Planning Response: A/36/18/OUT (Gladman Homes)

Planning Application A/36/18/OUT

Land West of Arundel Road, Angmering

Angmering Parish Council's Response to this application is as follows:-

Figure 5.2: Illustrative Masterplan.

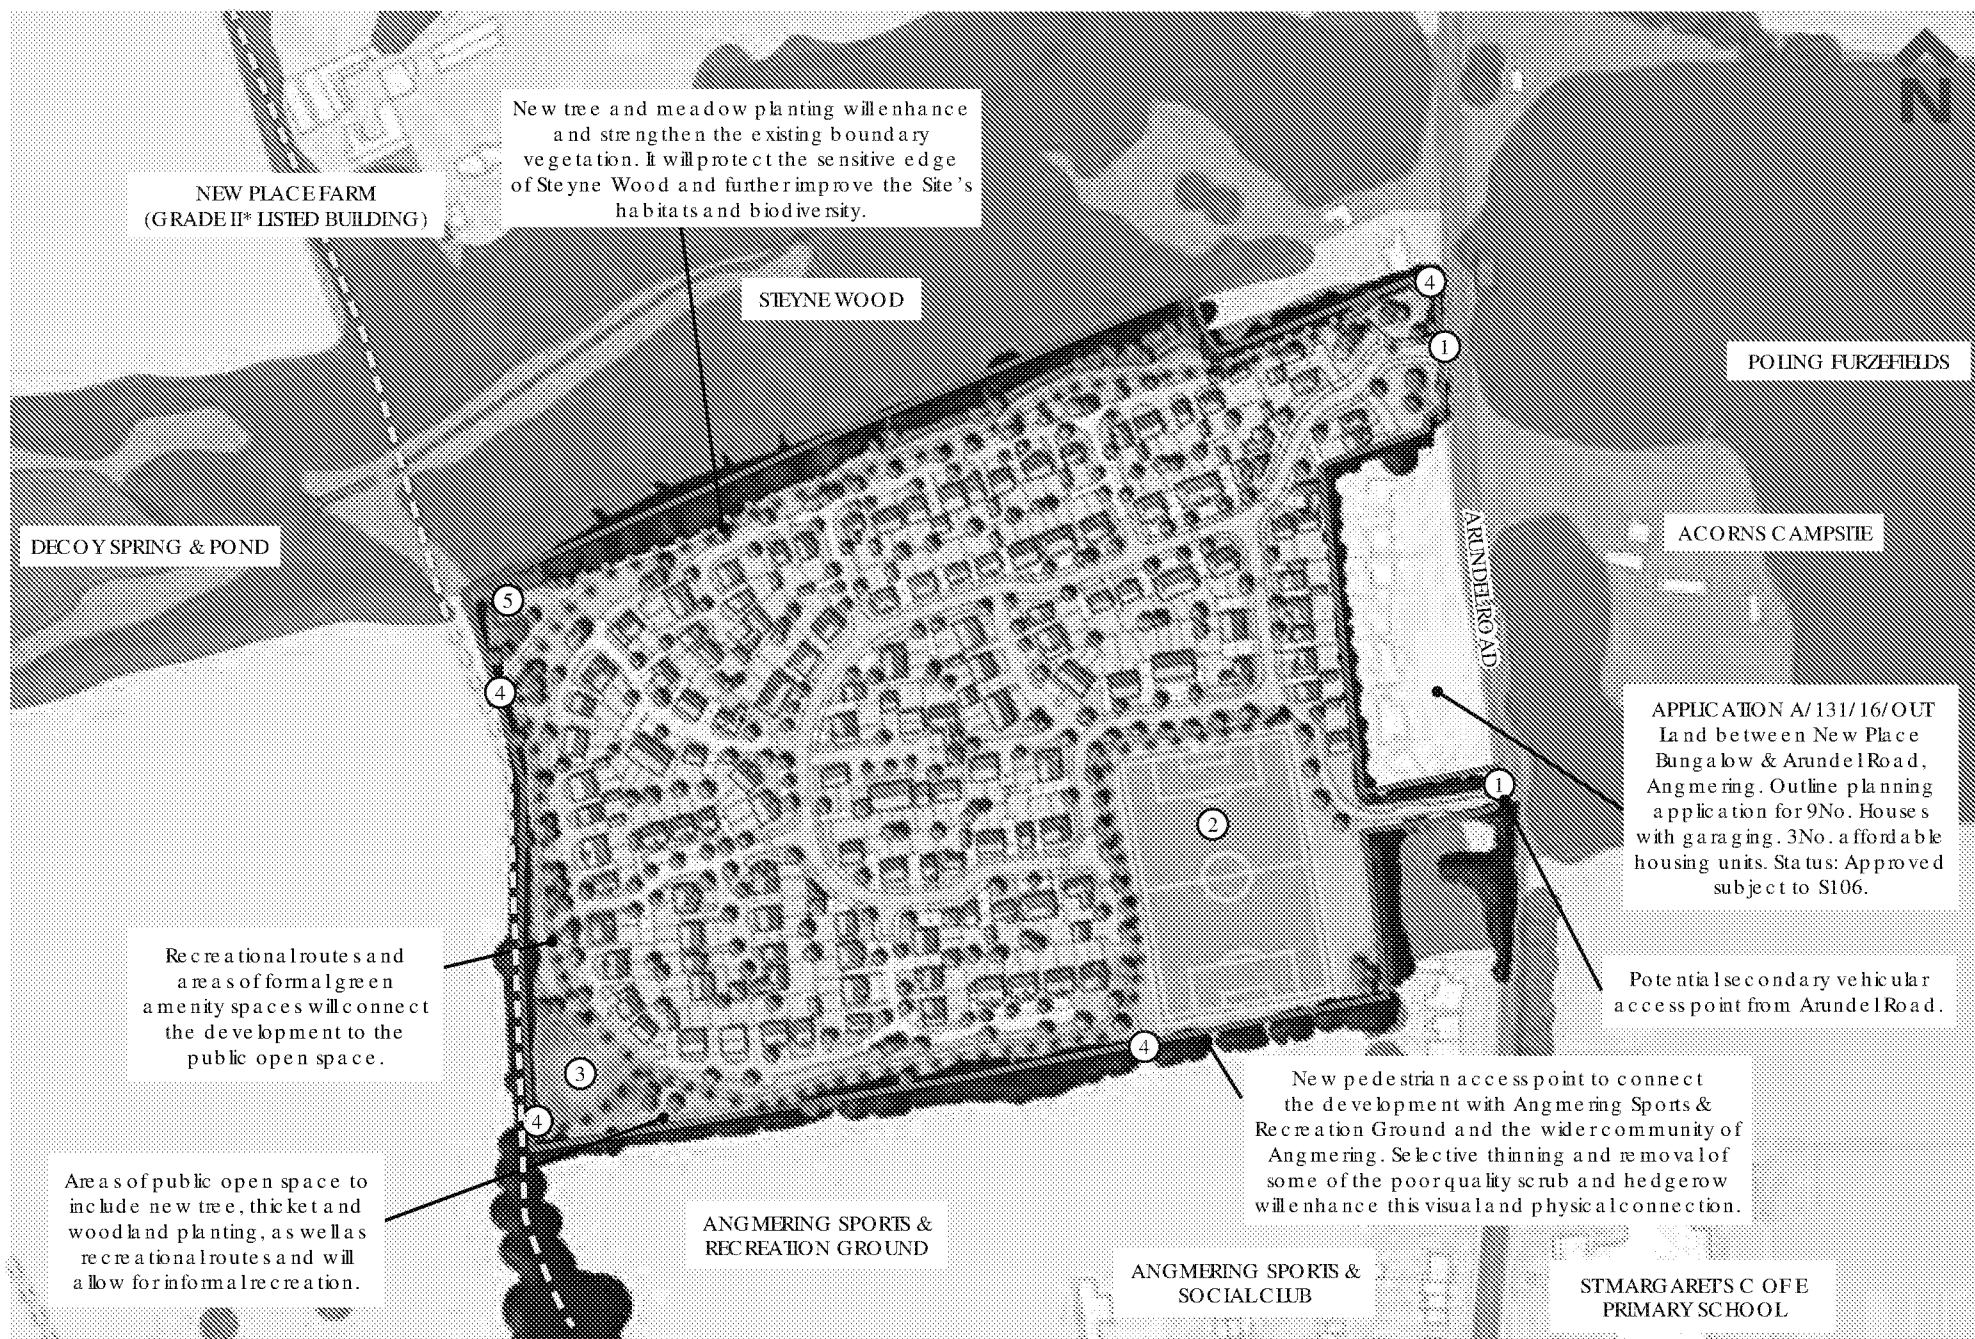
- The football pitch as shown, is **incorrectly aligned** and is unusable because there is **no extra car parking**, not enough **land around the pitch** and appears to be a pitch for the development rather than integrated with the Recreation Ground.

Figure 8: Proposed Offline Storage Tank

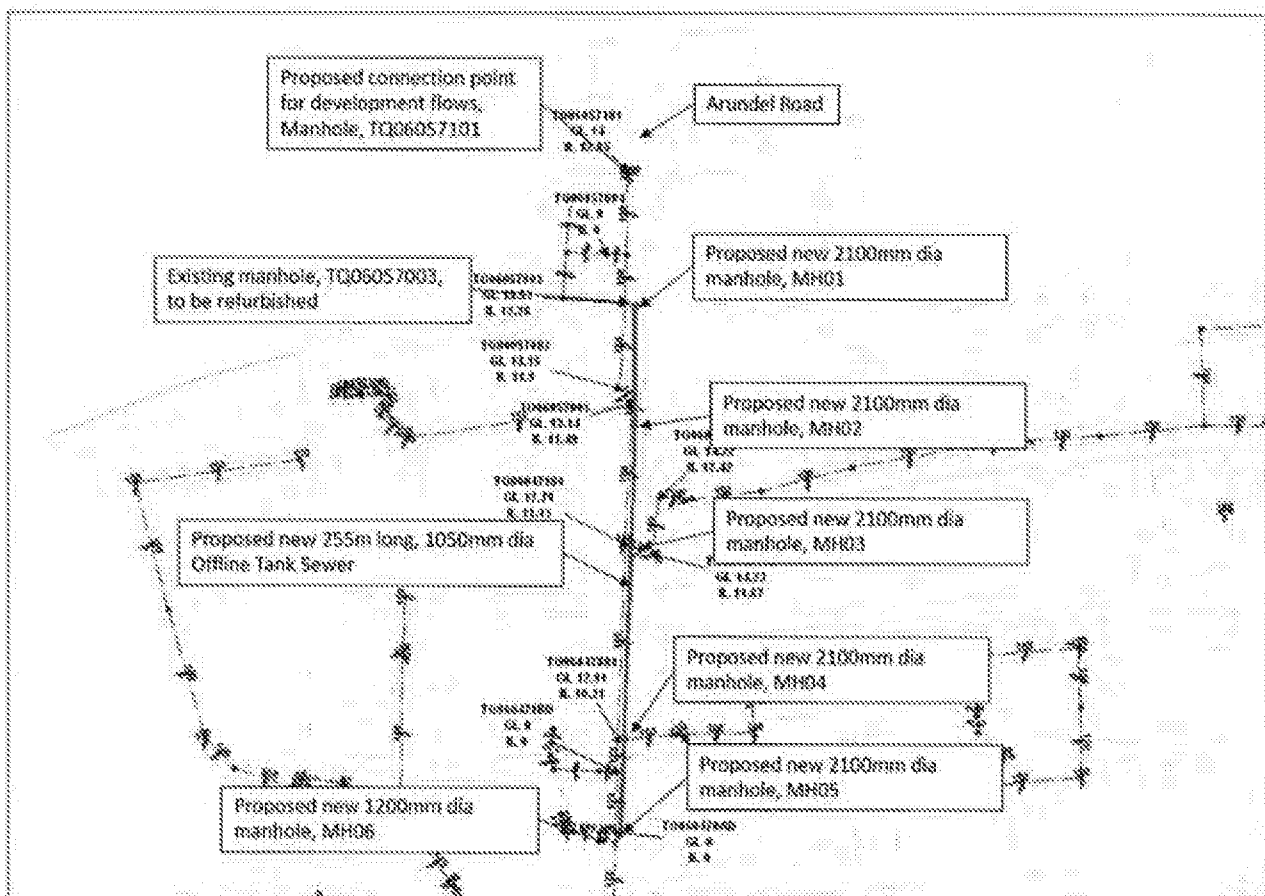
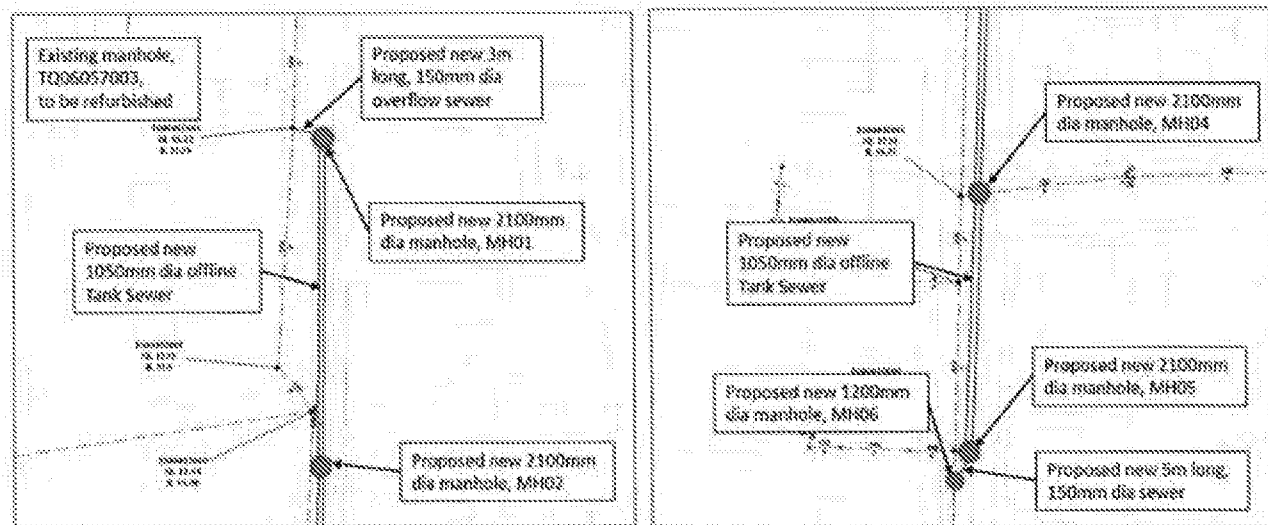
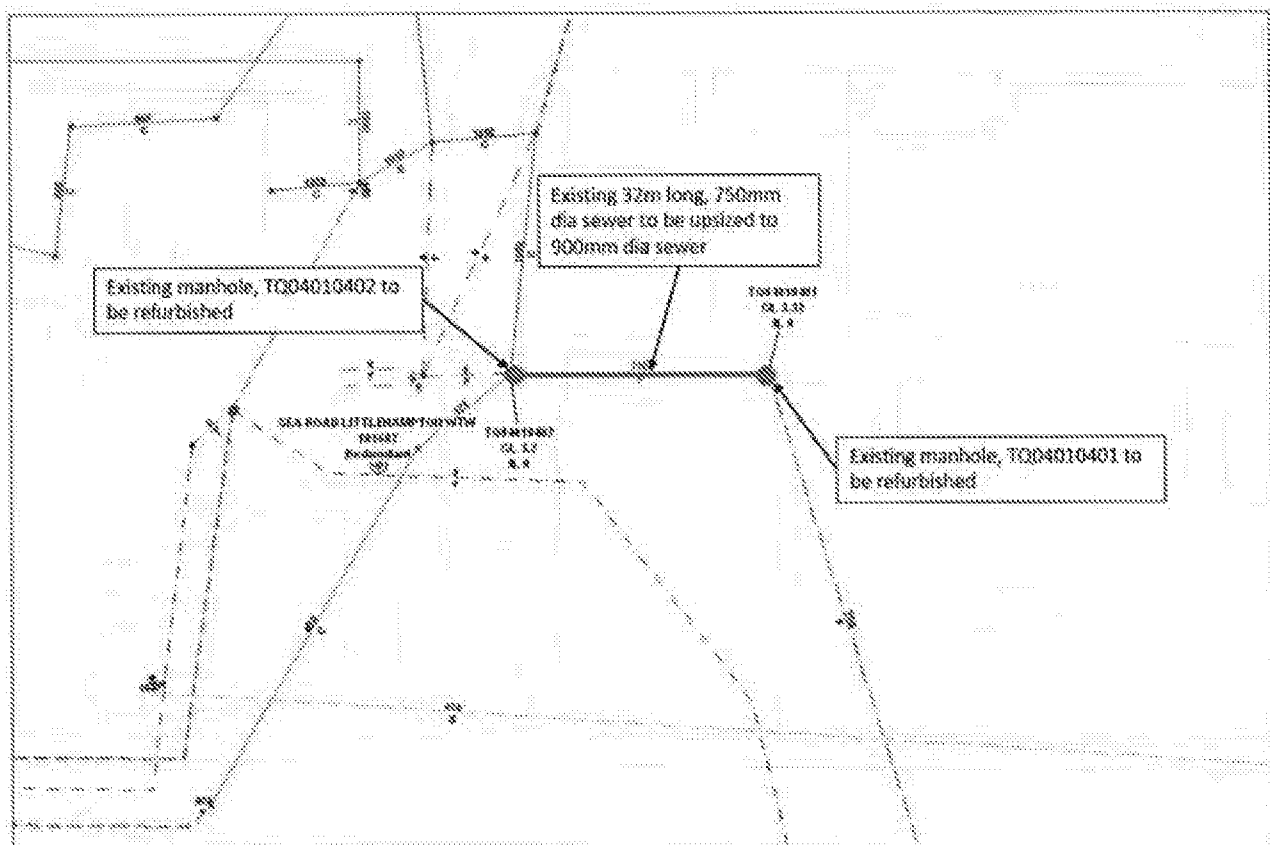
- 11) The developers response was to employ 'Utility Law Solutions' to request a 'Feasibility Study' of what would be required, but insisting that it is Southern Water's responsibility to ensure the work is done in time. All this, in addition to the other Strategic development in Angmering is unlikely to happen.
- 12) This is the problem with having substantial developments put forward which are not part of the Strategic Allocation and therefore subject to a **Sustainability Appraisal**. This is clearly a reason for not agreeing this application at this time.
